**Our Case Number:** ACP-323980-25

**Re:** Proposed Water Supply Project for the Eastern and Midlands Region  
in the counties of Clare, Limerick, Tipperary, Offaly, Kildare, and Dublin.

RE: (A) Direct planning application to An Coimisiún Pleanála under section 37E of the Planning and Development Act as amended in respect of a Strategic Infrastructure Development (Proposed Water Supply Project Eastern and Midlands Region) (ACP Ref. 323980); and  
(B) Uisce Éireann Compulsory Purchase (Water Supply Project Eastern and Midlands Region) Order, 2025 (ACP Ref 323982)

Peamount Healthcare wishes to make a number of observations on the above referenced Strategic Infrastructure Development application (the **Proposed Development**) by Uisce Éireann (UÉ). Peamount Healthcare also wishes to object to the draft Compulsory Purchase Order (CPO), and particularly the CPO of Plots No ACQ09a.2172 and ACQ09a.2175 on Drawing No IW/10001814/CA/09a.

Drawing Title
**FIGURE 5.8
TERMINATION POINT RESERVOIR
INDICATIVE SATELLITE CONSTRUCTION COMPOUND PLAN**

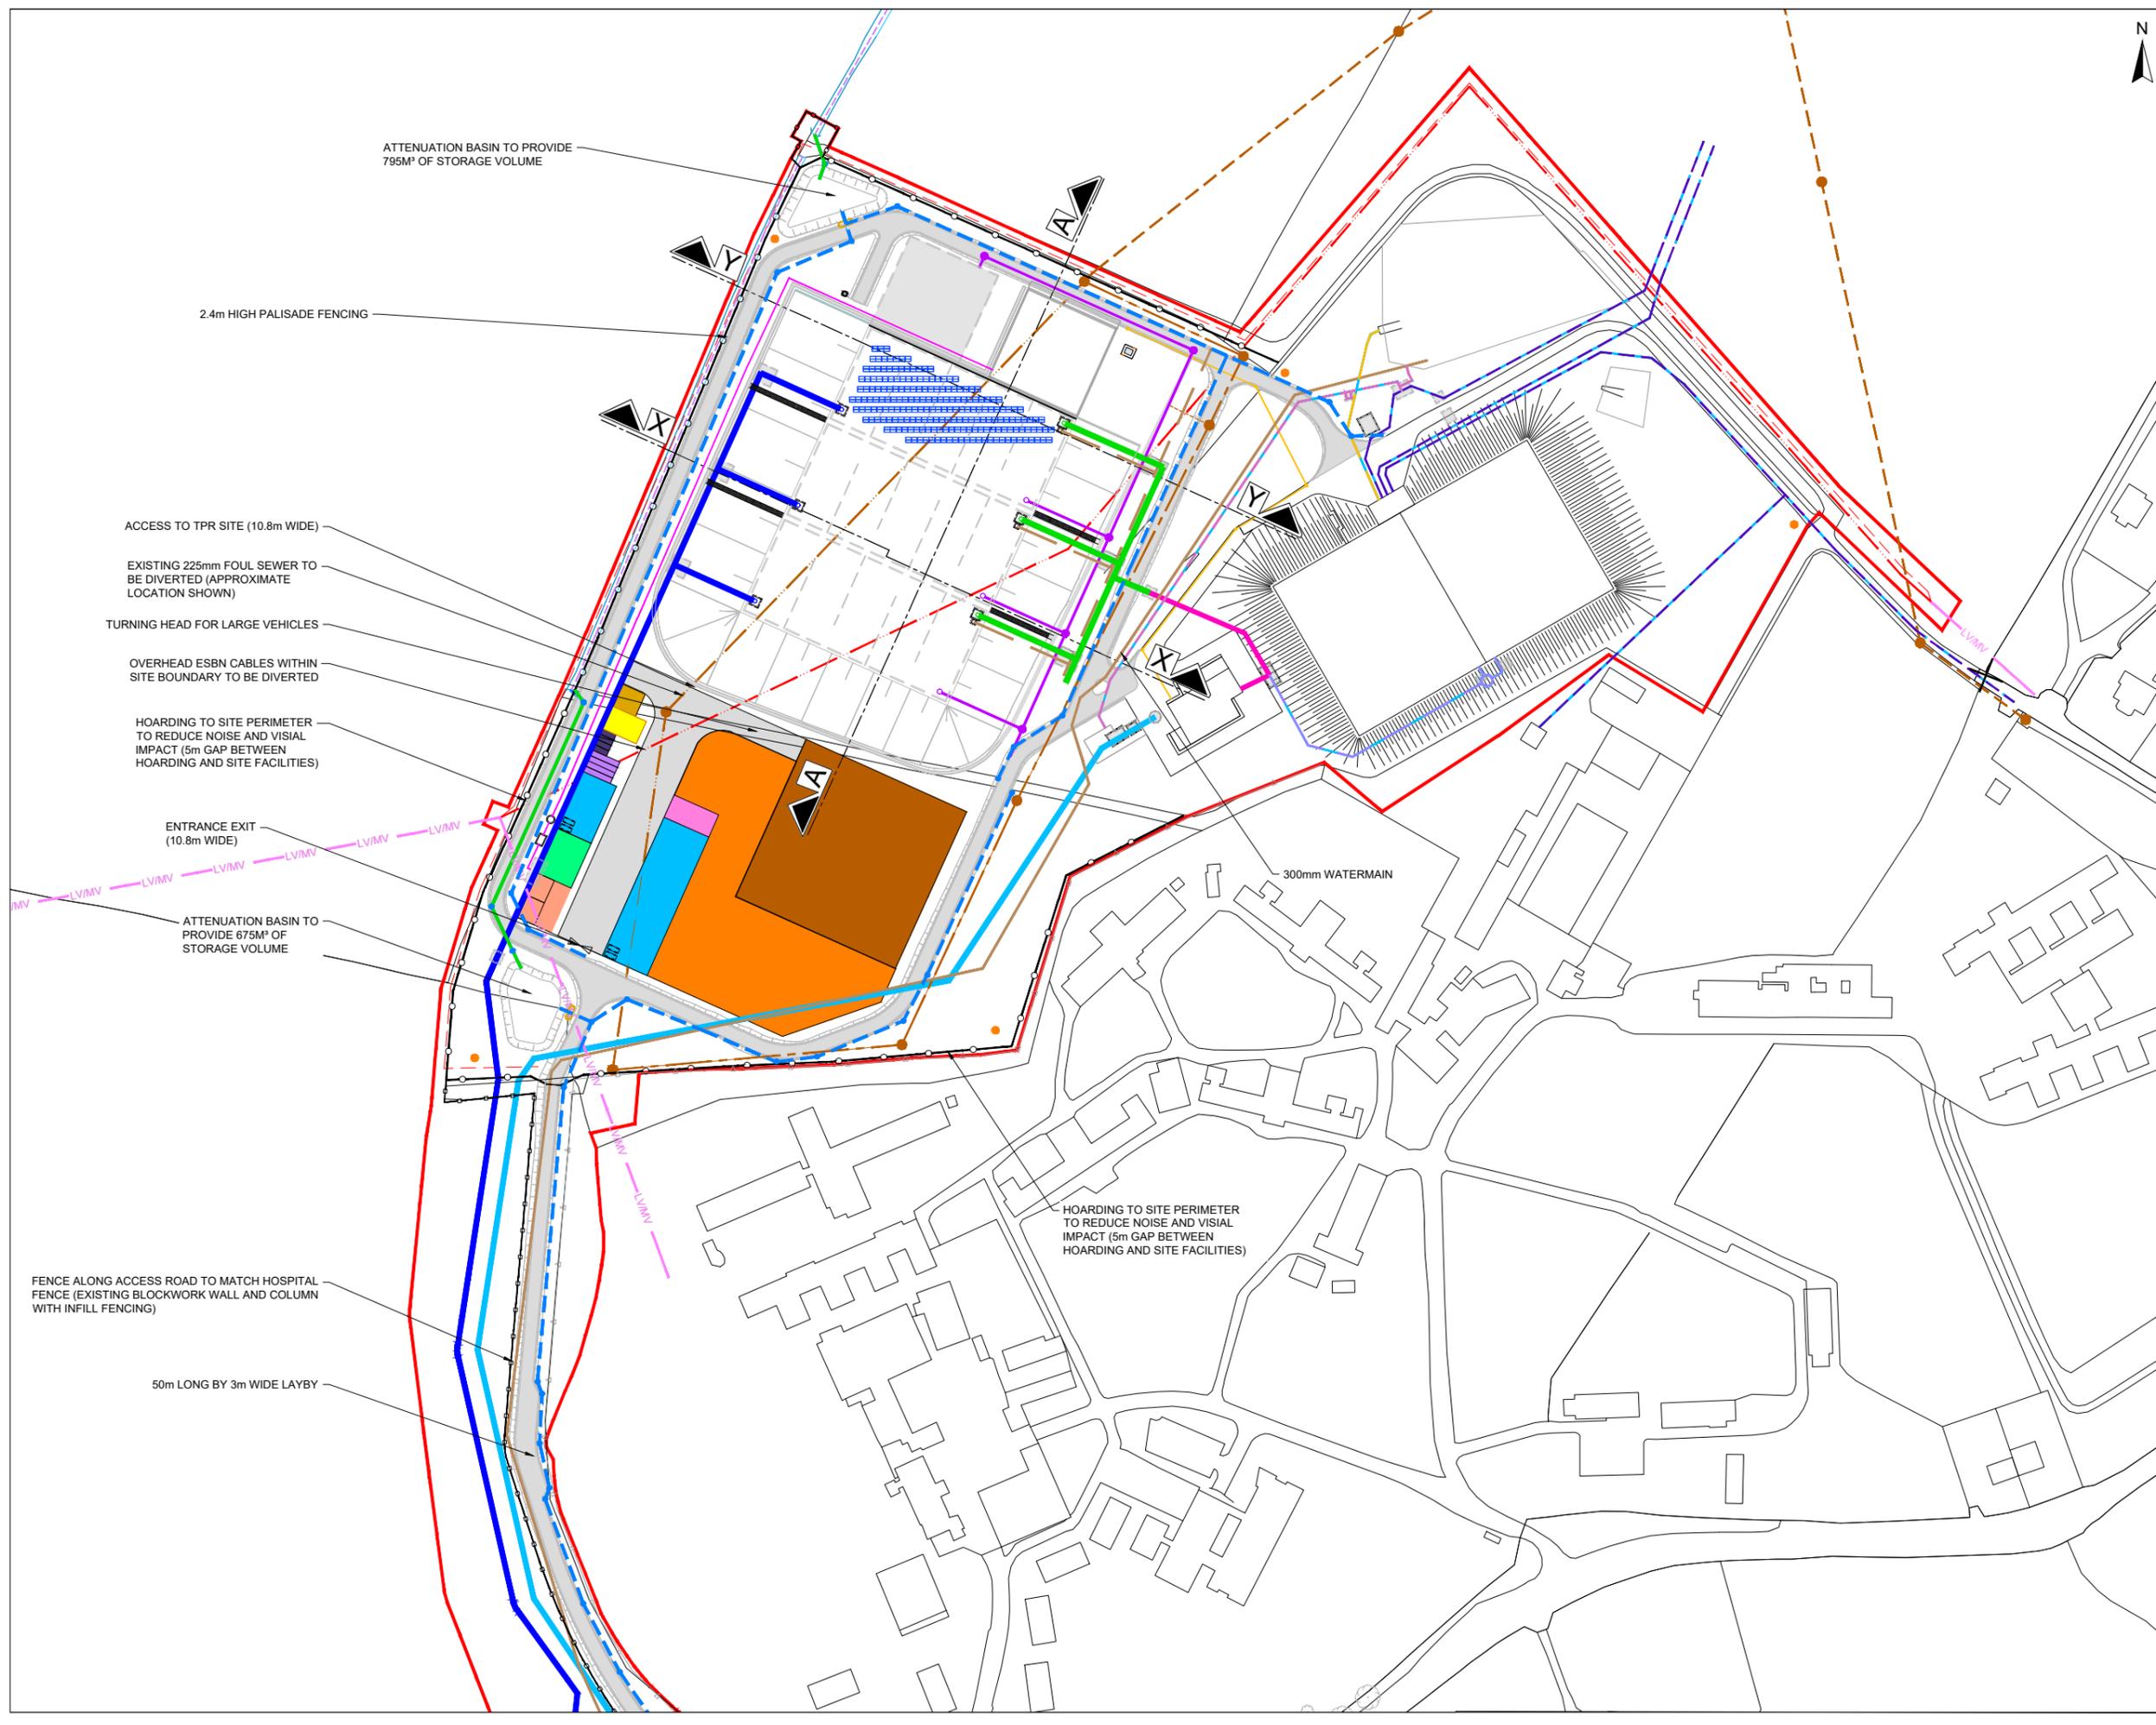
- 6.1 The proposed construction and permanent access to the new TPR runs along the western, and part of the northern, boundaries of the Peamount hospital campus. The proposed access is a T-junction onto the regional road R120 connecting Newcastle to Lucan. The new junction is 60 metres from a secondary access to the hospital and approximately 350 metres from the main entrance to the hospital site. This new junction and the construction road will be very close to Peamount Hospital and to its permanent residents living in residential units, as is shown in **Appendix 1**. The R120 is a relatively narrow regional road with several junctions and direct accesses in the vicinity of Peamount.

- 6.2 A ready alternative to this route exists via the Grange Castle West Access Road which is constructed as dual and single carriageway including a roundabout with a southern spur which terminates less than 300 metres from the site of the proposed new reservoir. The Part 8 planning permission for the road includes the spur and a roundabout at the northwest corner of the reservoir site.

- 6.3 Use of this alternative access would remove all construction and operational traffic from the vicinity of Peamount Hospital using existing, or already permitted public infrastructure that is wider, engineered to modern standards and generally more fit for purpose.

- 6.4 This alternative construction access arrangement was not considered as part of the Chapter 4 Alternatives Assessment despite Peamount Hospital addressing the problems with the proposed access in the non-statutory consultation.
